**Consultation Response from KC,  
Lead Local Flood Authority**

**2025/93355 Land off, Woodward Court, Mirfield, WF14 0PY**

**Erection of 75 residential dwellings with associated landscaping, open space, highways and drainage infrastructure**

**Date Responded: 22<sup>nd</sup> March 2026  
Responding Officer: Paul Farndale  
Responding Ref:**

A Key plan updated.
SITE SECTIONS - 2520-SS-02A
 WOODWARD COURT, MIRFIELD
 BELLWAY HOMES
 SCALE: 1:200@A1 - NOVEMBER 2025

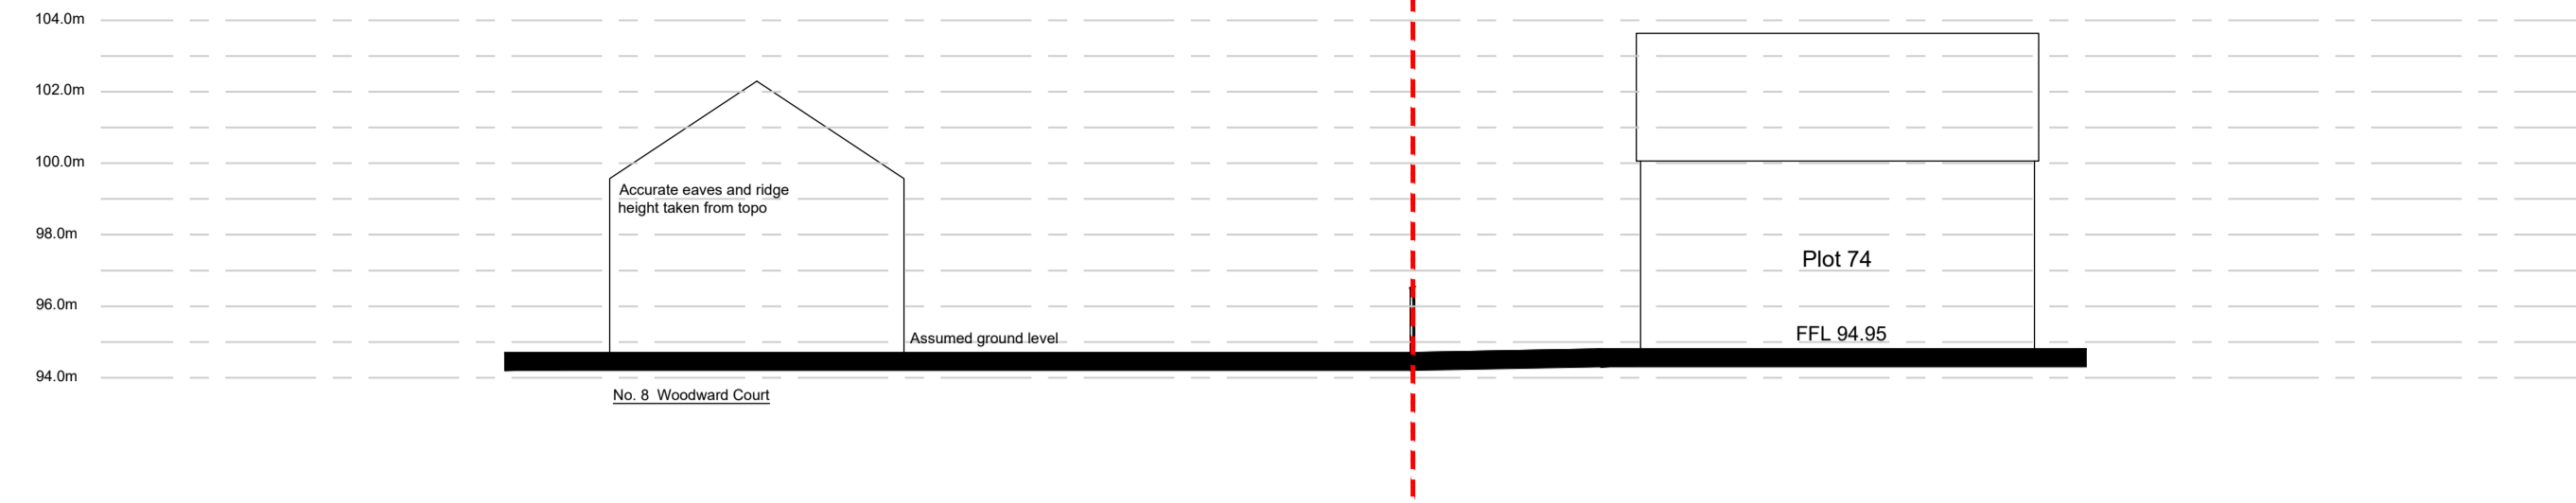
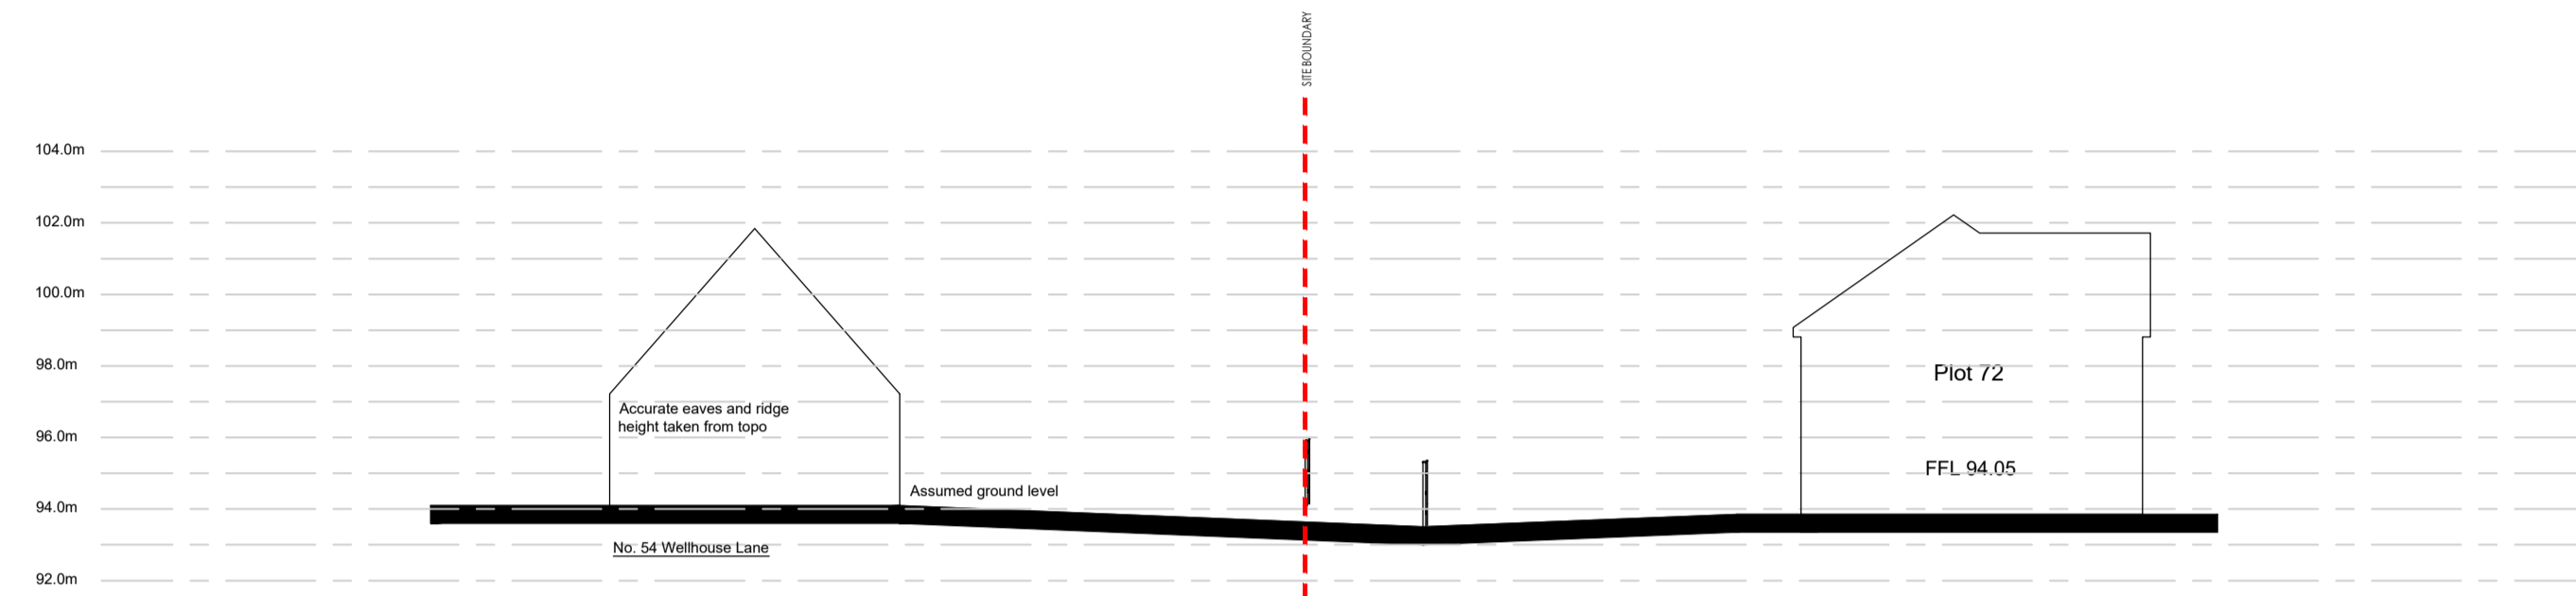
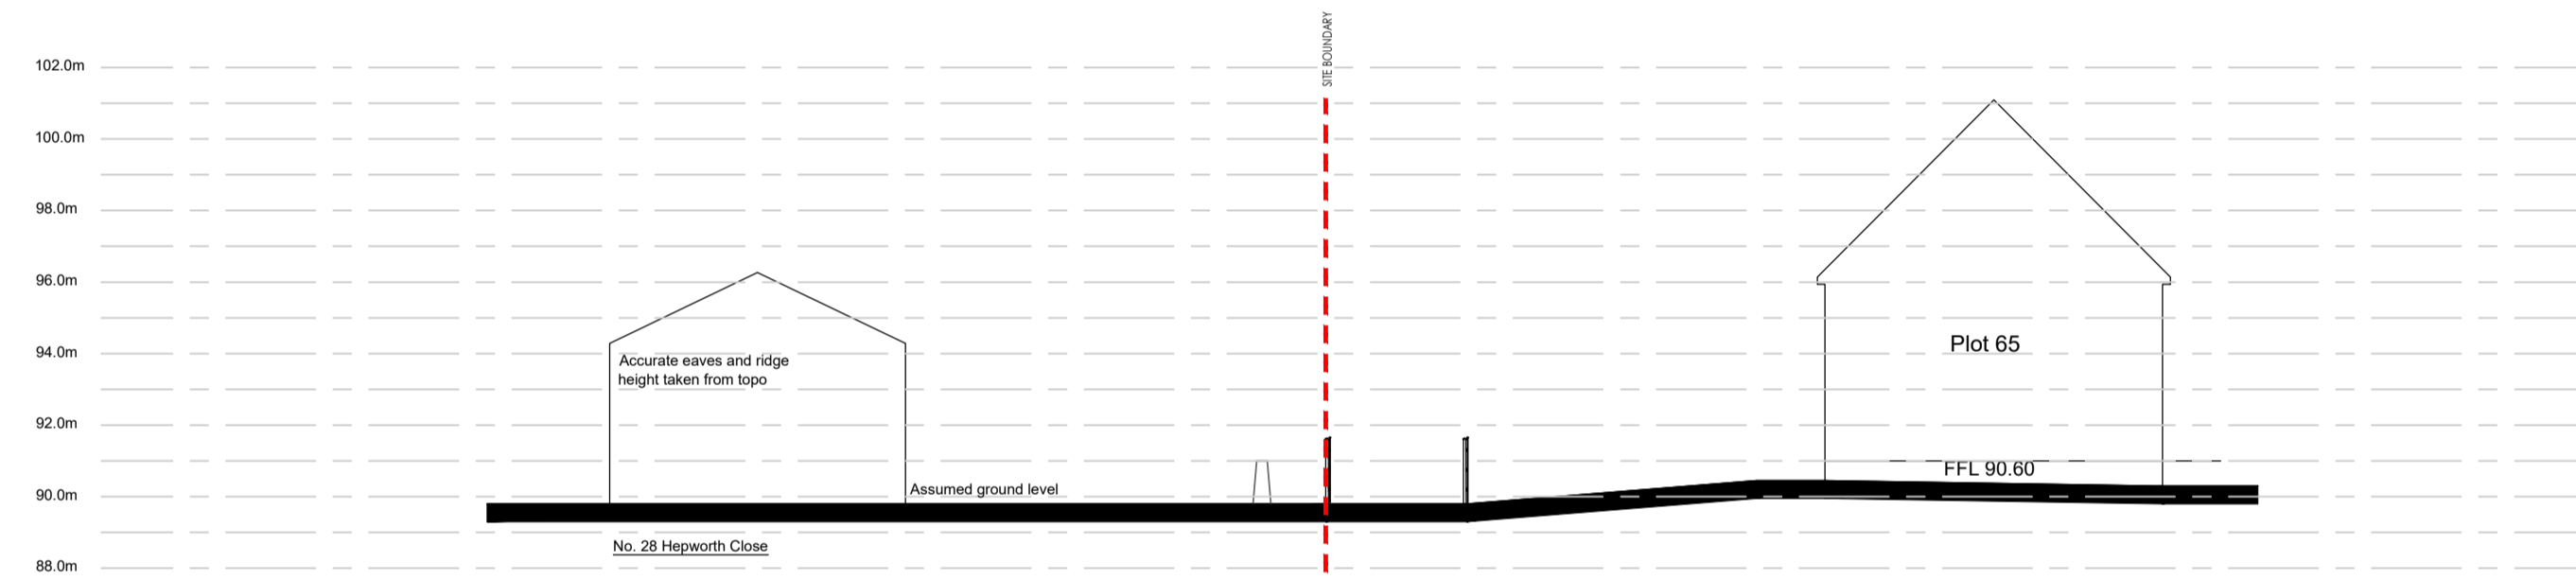
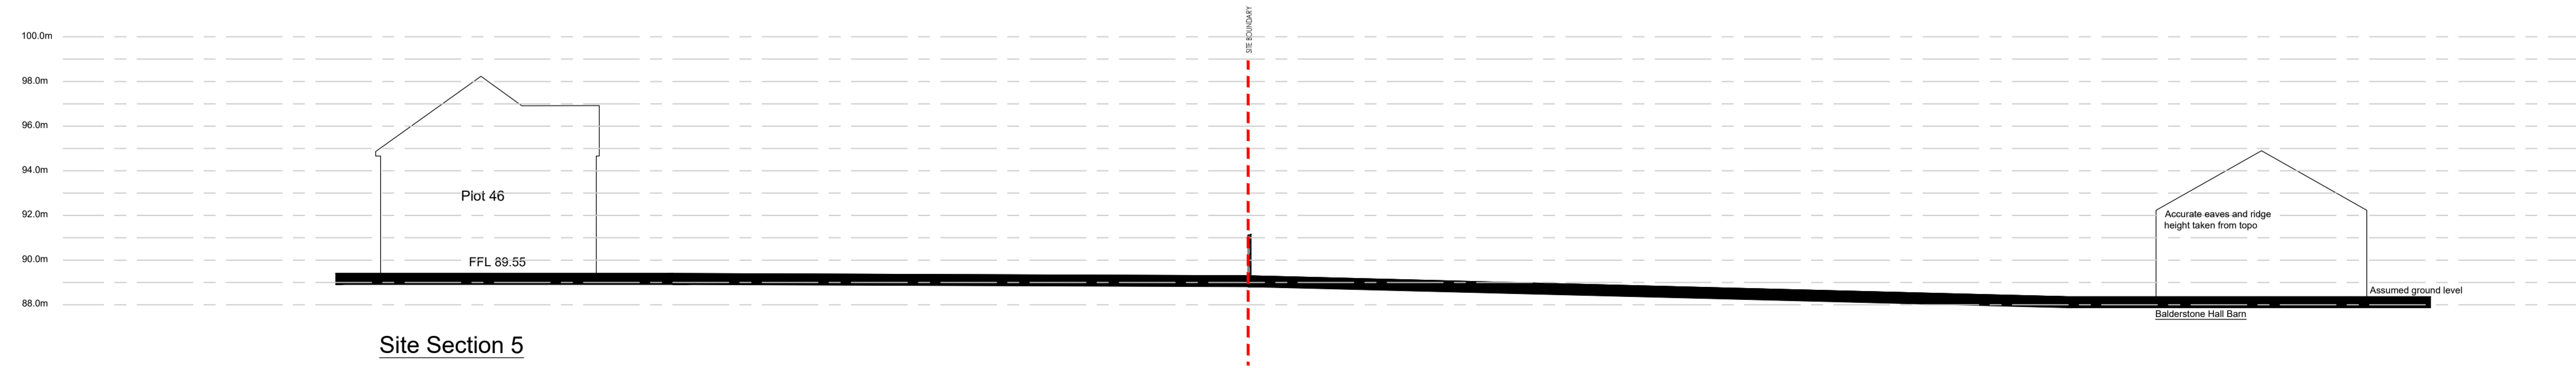
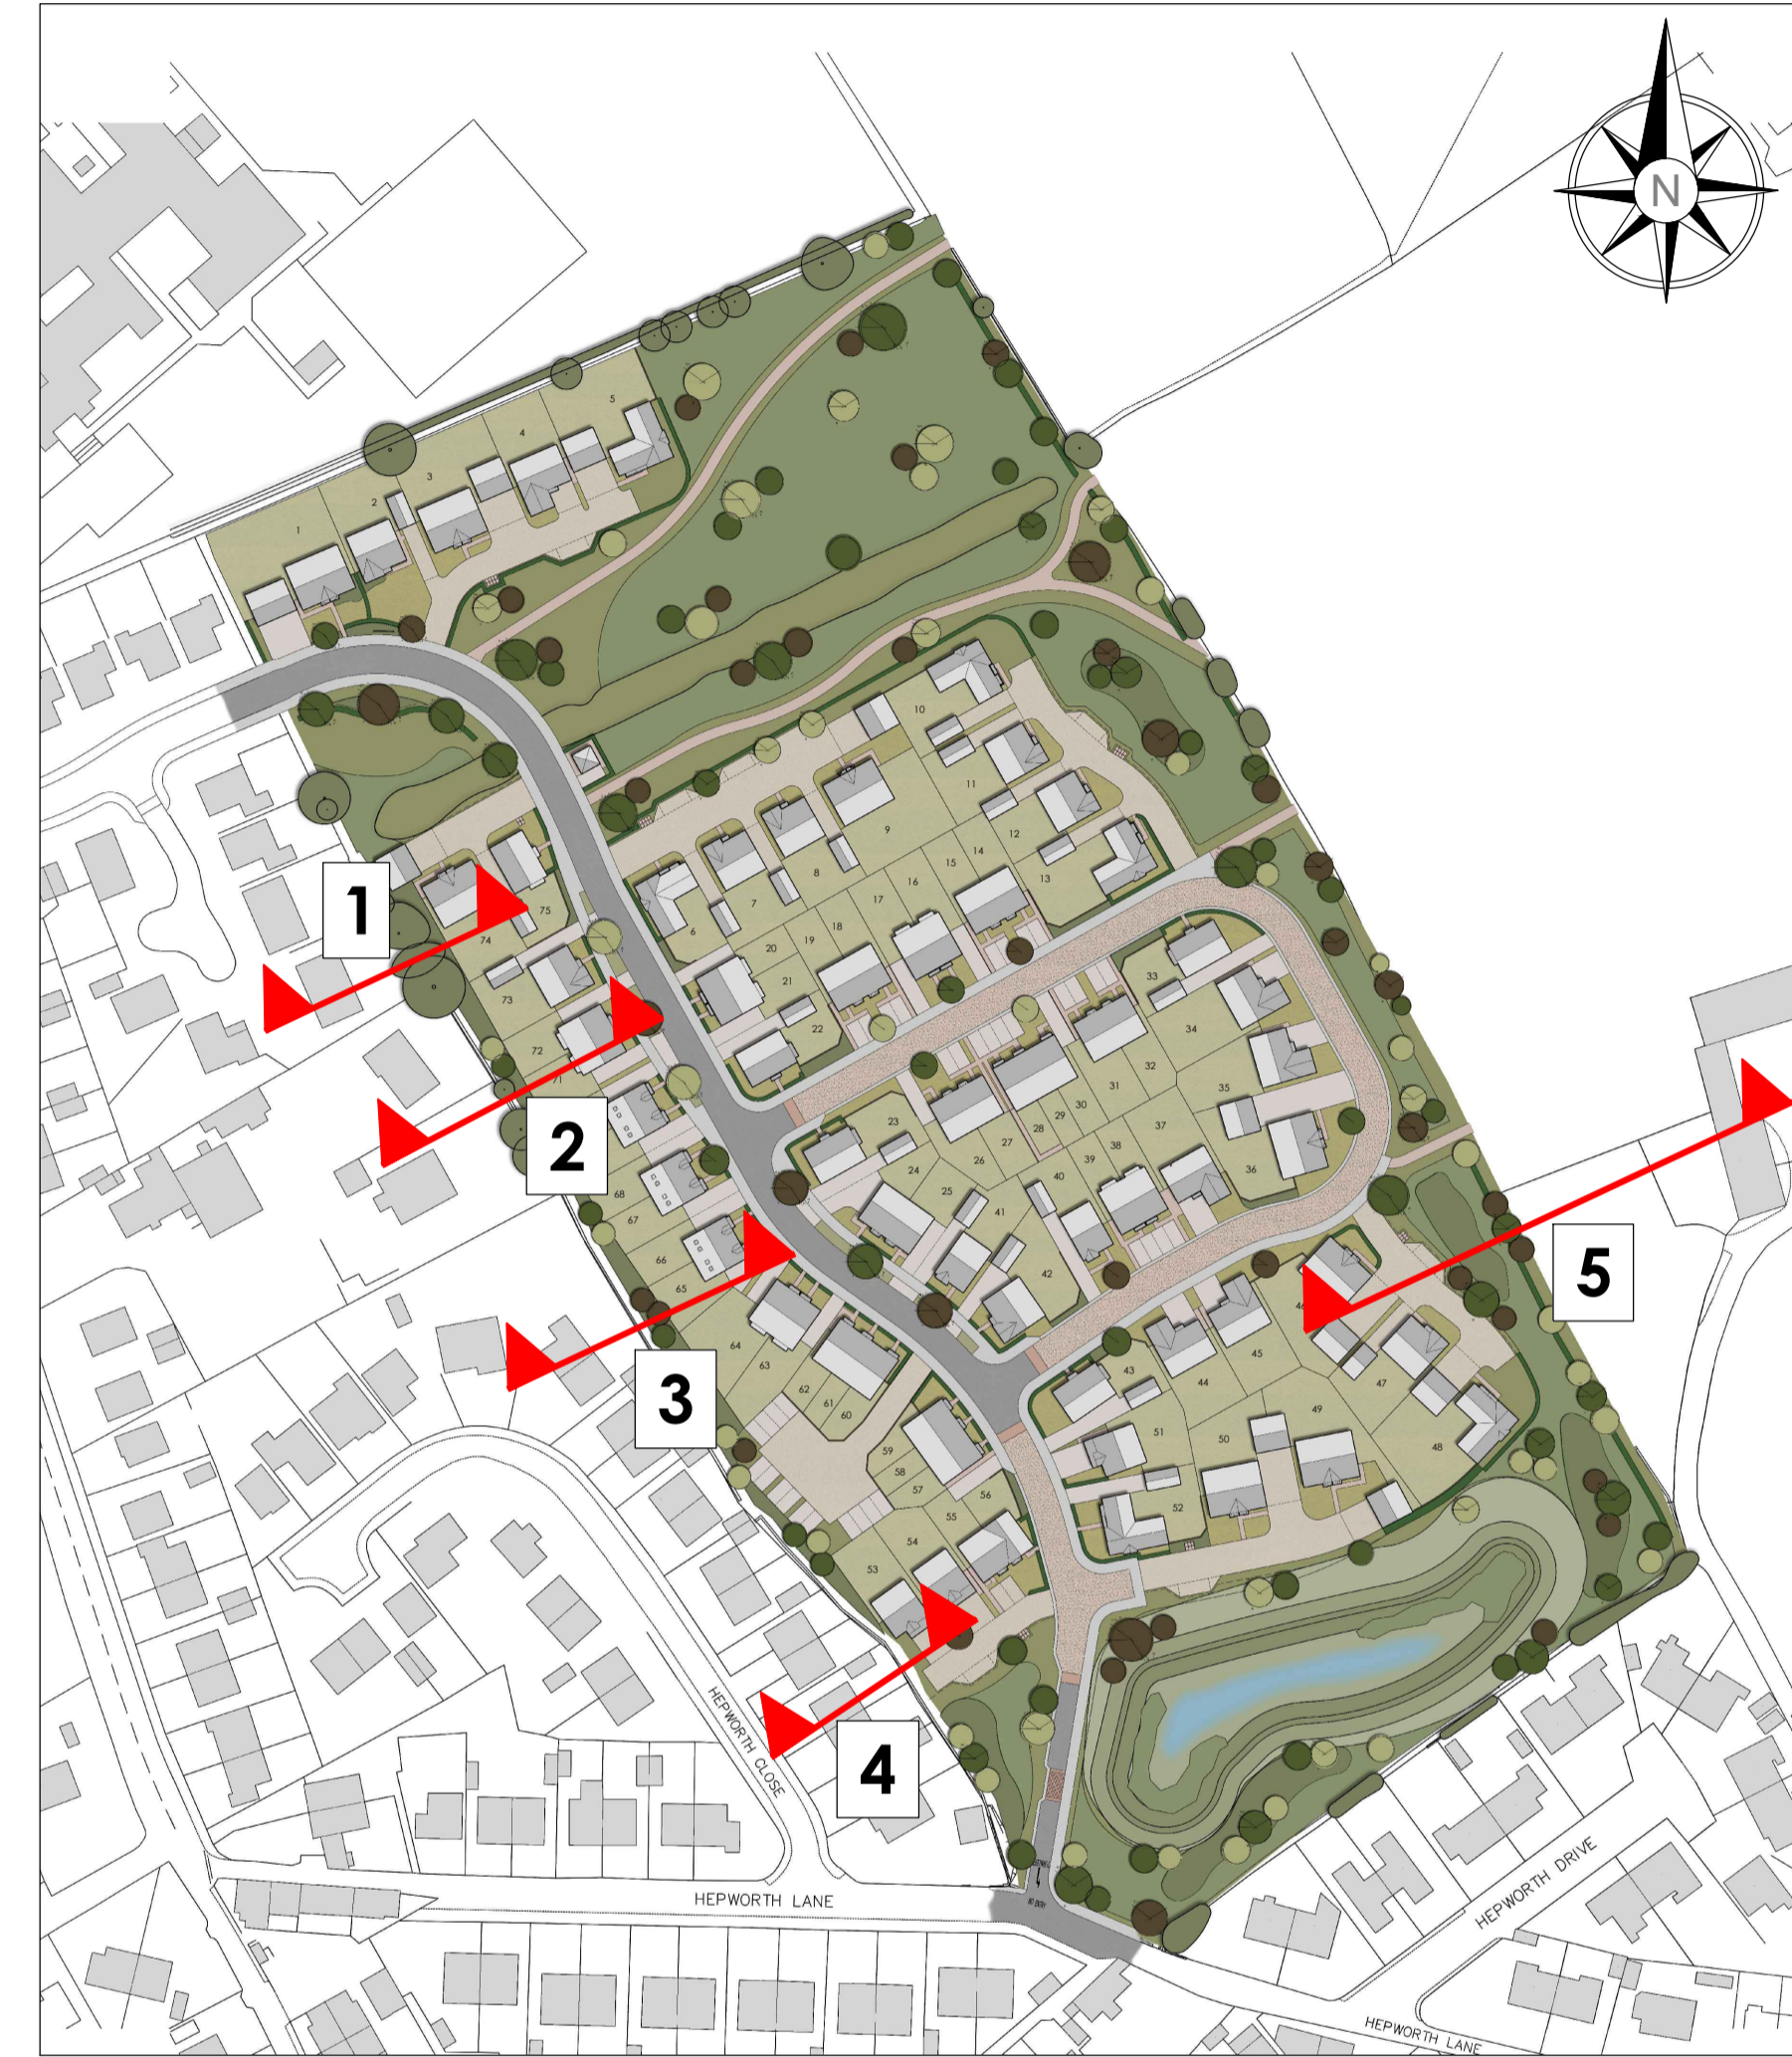
**We believe cross section of substrata across the site should be provided and an independent assessment from a suitably competent geotechnical specialist be sought on behalf of the Council.**
